From: [REDACTED]
Sent: 09 August 2026 15:49
To: Planning
Subject: FAO: Anna Robinson URGENT: Additional Material Objection – Application 3/2026/0354 (13 Brookside)

I am writing as the [REDACTED] to submit an important, supplementary material objection regarding planning application **3/2026/0354** for the proposed development at **13 Brookside, Old Langho, BB6 8AP**.

Notes
This drawing is the property of IDC Home Architecture Ltd and copyright is reserved by them. This drawing is not to be copied or disclosed by or to any unauthorised persons without the prior written consent of IDC Home Architecture Ltd.

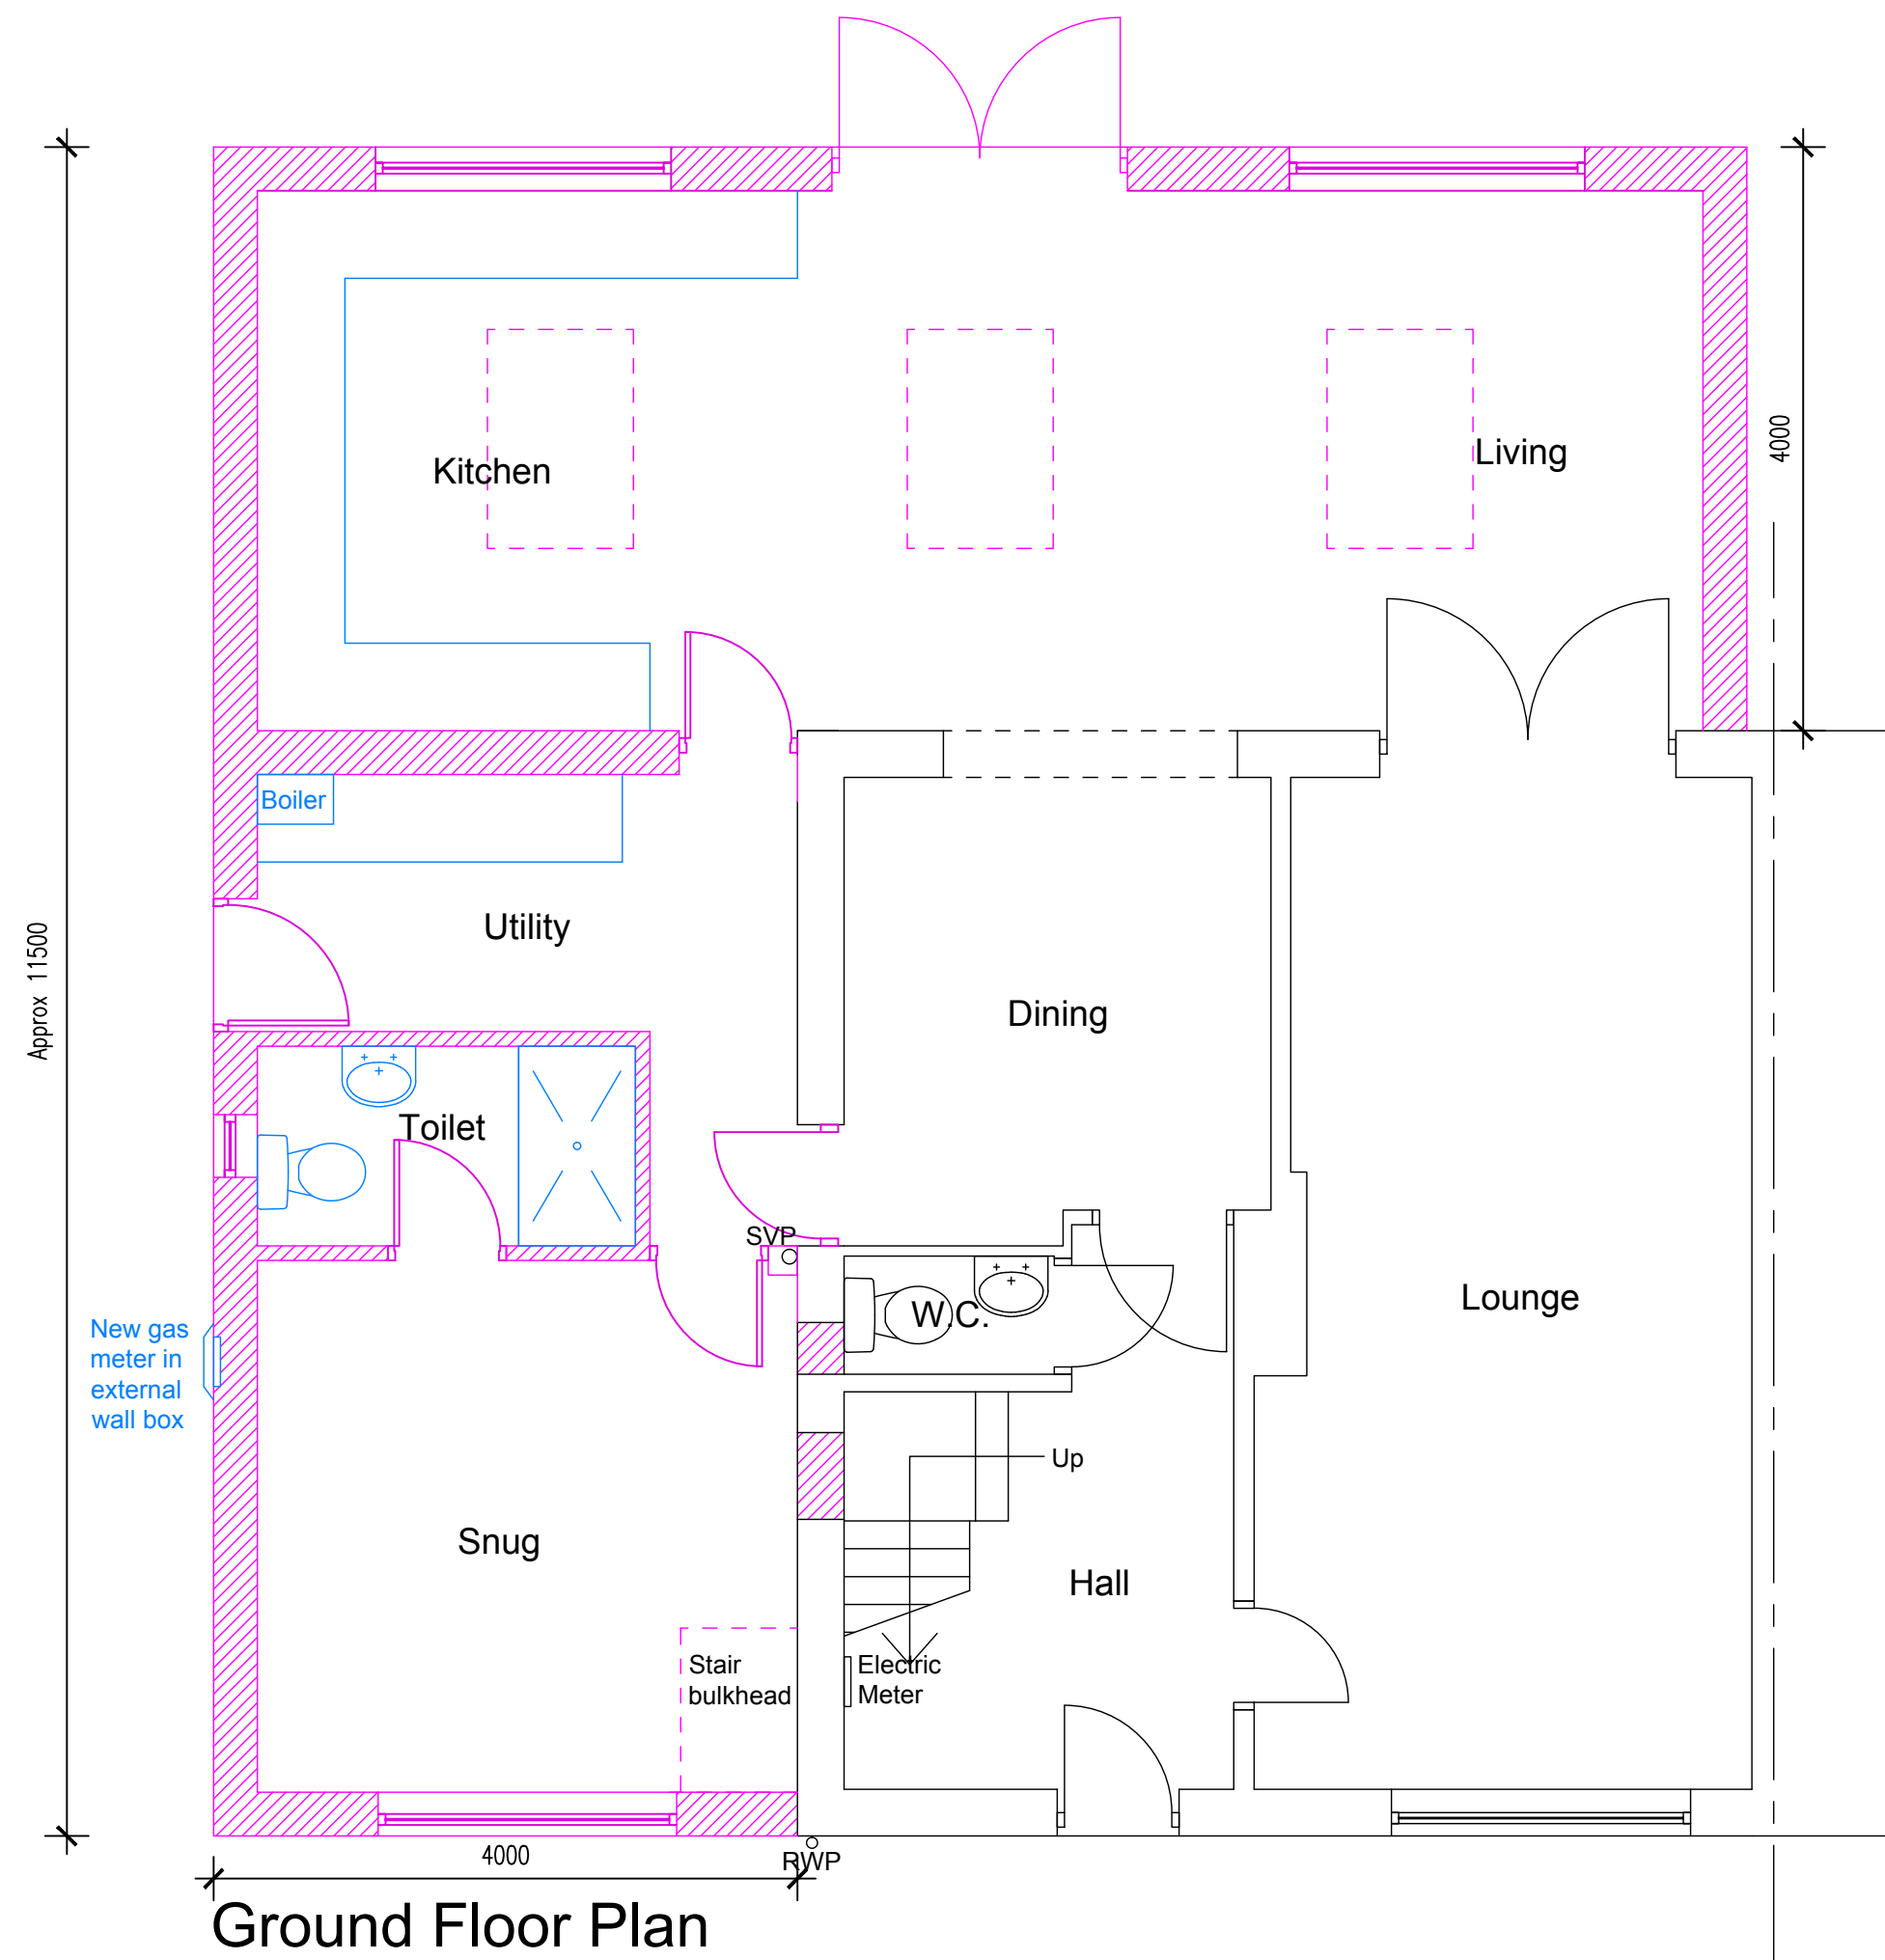
The proposed demolition of the side structure to make way for a substantial two-storey side extension and single-storey rear extension represents a severe overdevelopment of the plot. The scale and massing of this construction will significantly erode the existing sense of openness on the street. It introduces an overly dominant, intrusive, and uncharacteristic form that is too large for the narrow separation distances between properties on Brookside. This layout conflicts directly with **Policy DMG1 of the Ribble Valley Local Plan**, which strictly protects local residential amenity against overbearing structures.

The plans currently reference a first-floor side/front window. Given the narrow distances between the properties, I hold serious concerns regarding the potential for intrusive overlooking if clear glass is permitted in this location. While a non-habitable room window is manageable with strict obscure-glazing conditions, any use of clear-glazed windows in these close proximity zones will create an unacceptable, severe level of direct overlooking into private gardens and habitable windows. If any amended plans or layout adjustments are submitted by the applicant that alter the window treatments, I formally request that the Council triggers a fresh, statutory 14-day re-consultation period.
